DELEGATED HOUSEHOLDER DECISION

Item No.	Report of the Head of Planning, Sport and Green Spaces	
Address	25 NORTH HYDE ROAD HAYES	
Development:	Part two storey, part single storey side extension and single storey rear extension	
LBH Ref Nos:	31853/APP/2013/3176	
Drawing Nos:	Location Plan to Scale 1:1250 06 03 Rev. A 01 04 05 02	
Date Plans Received:	25/10/2013	Date(s) of Amendment(s):
Date Application Valid:	08/11/2013

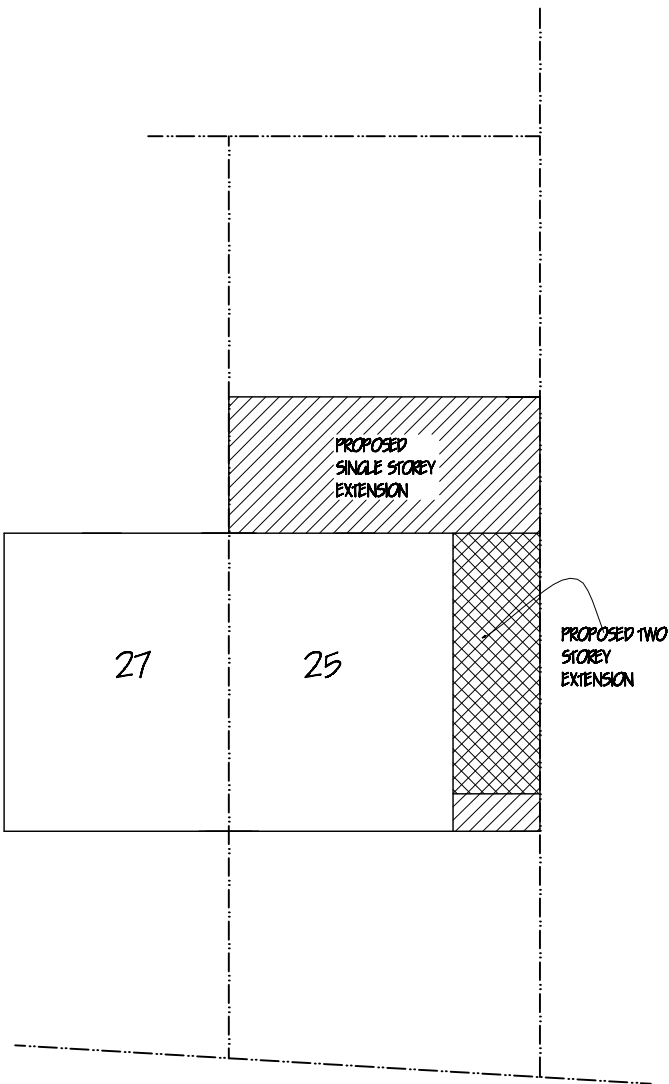
The proposal would add an additional bedroom to the property and guidance set out in the HDAS Residential Extensions requires properties with 3 or more bedrooms to provide a minimum of 60 sq. m. of rear garden area. As a result of the side and rear extensions only 55m² of private external amenity space would remain, to the detriment of current and

future occupiers and as such, the proposal fails to satisfy the requirements of policy BE23 of the Hillingdon Local Plan (November 2012) and the SPD HDAS: Residential Extensions.

The proposal fails to provide amenity space of sufficient size and quality commensurate to the size and layout of the extended dwelling, resulting in an over-development of the site detrimental to the residential amenity of the existing and future occupiers. As such the proposal would provide a substandard form of accommodation contrary to Policy BE23 of the Hillingdon Local Plan: Part Two - UDP Saved Policies (November 2012) and the adopted Supplementary Planning Document HDAS: Residential Extensions.

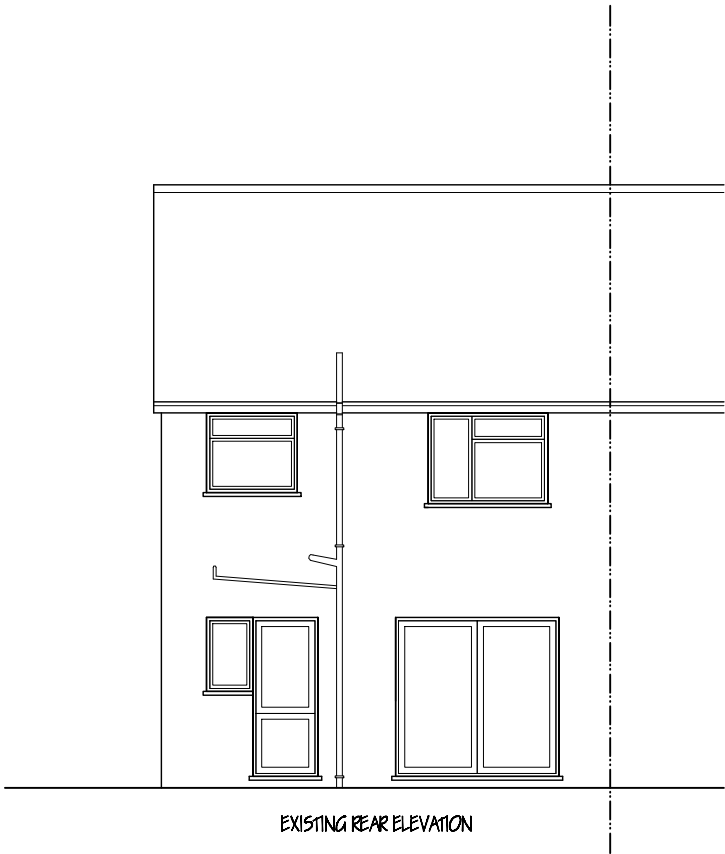
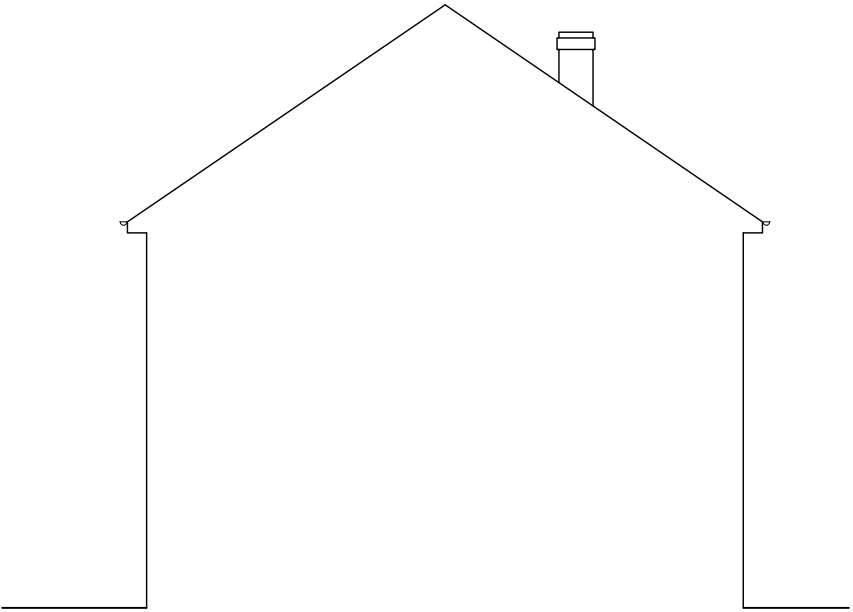
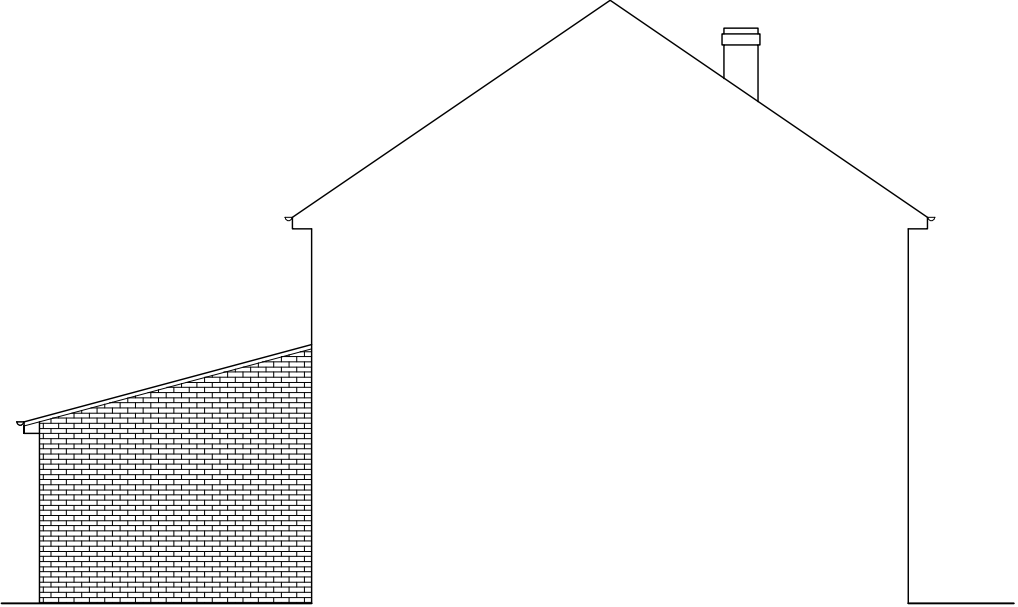
The proposed two storey side extension would be less than two thirds the width of the original house. However the ridge height of the extension would not be 0.5m below the height of the existing house. The plans are not accurate in terms of the set down in the ridge line of the extension and the set back from the first floor level. In the absence of clear and accurate plans it would not be possible to determine which scheme is being proposed and the overall impact to the streetscene could not be fully assessed. However, the ground floor would be set in line with the front elevation of the dwelling and not set back by 1.0m as required by HDAS. It is therefore considered that, which ever design in the plan shown is considered, the two storey side extension would be detrimental to the architectural composition of the original house and would fail to appear subordinate to the original dwelling. In addition, as the proposal will be constructed directly up to the boundary, it is deemed to detract from the visual amenities of the surrounding area and as a result would fail to be in compliance with Policy BE1 of the Councils Local Plan: Part 1 - Strategic Policies, and policies BE13, BE15, BE19 and BE22 of the Hillingdon Local Plan (November 2012) plus section 5.0 of HDAS: Residential Extensions.

The proposed two storey side extension, by virtue of its siting in a prominent location, size, scale and design, including the lack of a set back from the frontage at all levels and the lack of a roof set-down, would fail to appear as a subordinate addition and would thus be detrimental to the appearance of the original house, the symmetry of the pair of semi-detached properties of which it forms a part and the visual amenities of the street scene and the character and appearance of the wider area. The proposal is therefore contrary to Policy BE1 of the Hillingdon Local Plan: Part One - Strategic Policies (November 2012), Policies BE13, BE15 and BE19 of the Hillingdon Local Plan: Part Two - UDP Saved Policies (November 2012) and the adopted Supplementary Planning Document HDAS: Residential Extensions.

- 2 You are advised that the plans submitted are not consistent or accurate in that the front and rear elevations show a set down in the ridgeline of the roof and the proposed floor plans and side elevation show a set back from the principal elevation and a resultant set down in the ridgeline of the extension. Any future submission should ensure accuracy between all of the elevations and floor plans in their design.

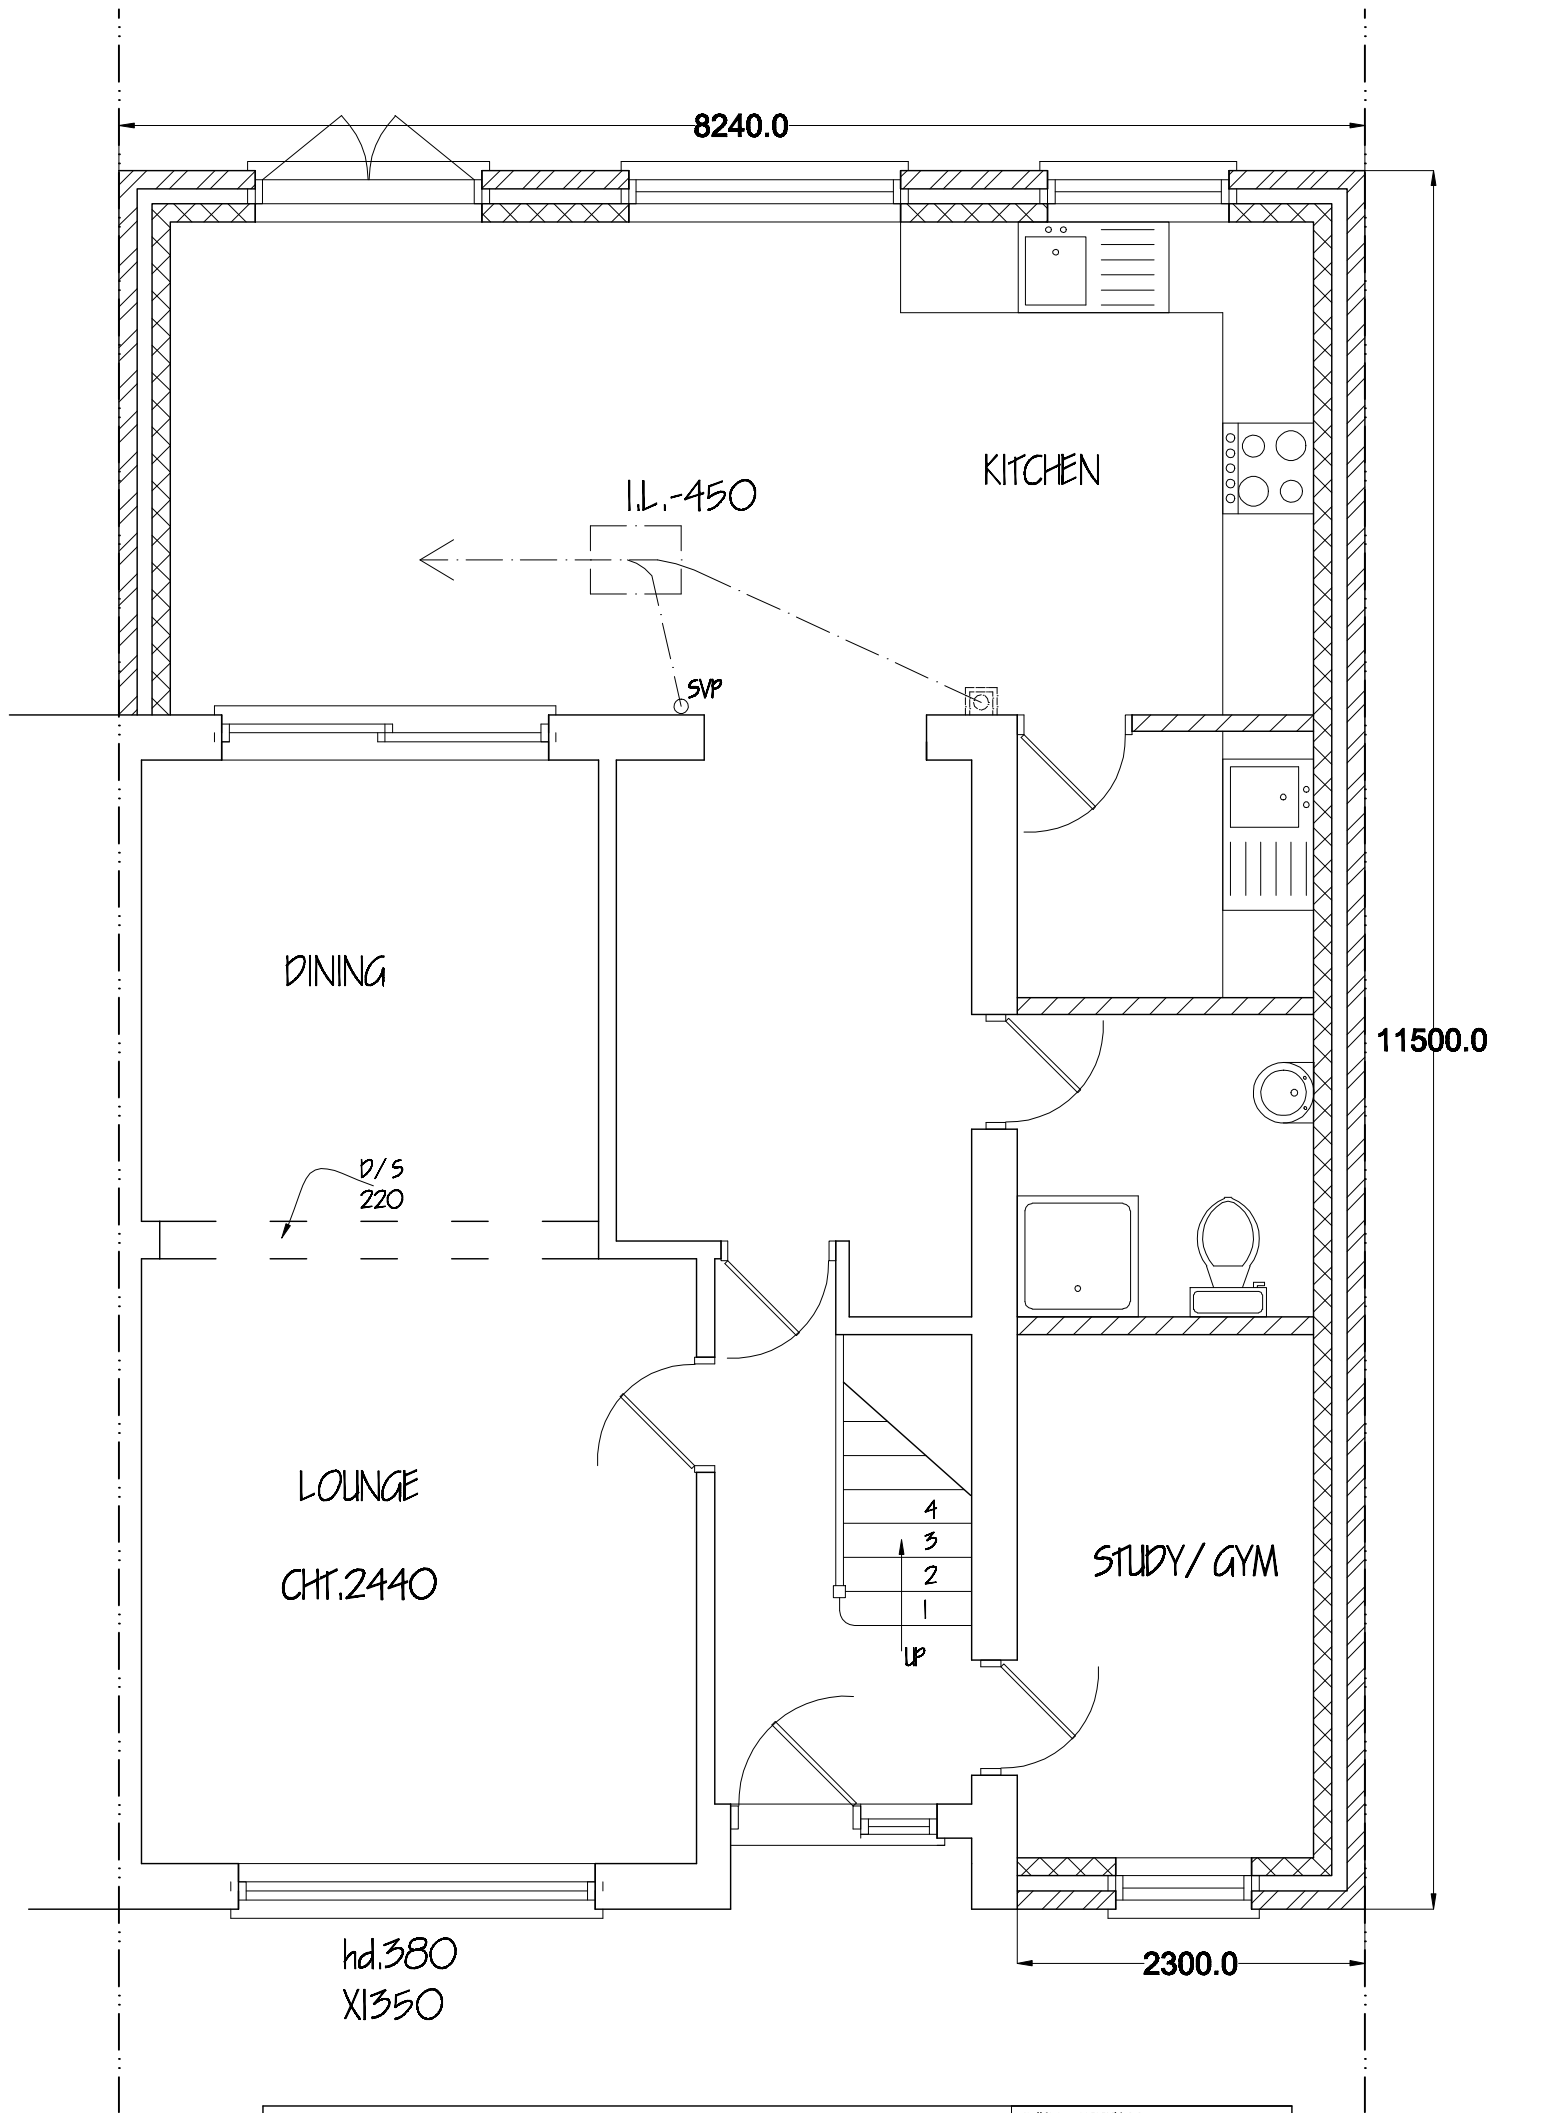
In the absence of accurate and consistent drawings of the proposed extensions, it is not possible to fully assess the planning merits of this proposal in terms of its impact upon the appearance of the dwelling and the visual amenities of the surrounding area. The proposal is therefore contrary to Policy BE1 of the Hillingdon Local Plan: Part One - Strategic Policies (November 2012), Policies BE13, BE15 and BE19 of the Hillingdon Local Plan: Part Two - UDP Saved Policies (November 2012) and the adopted Supplementary Planning Document HDAS: Residential Extensions.
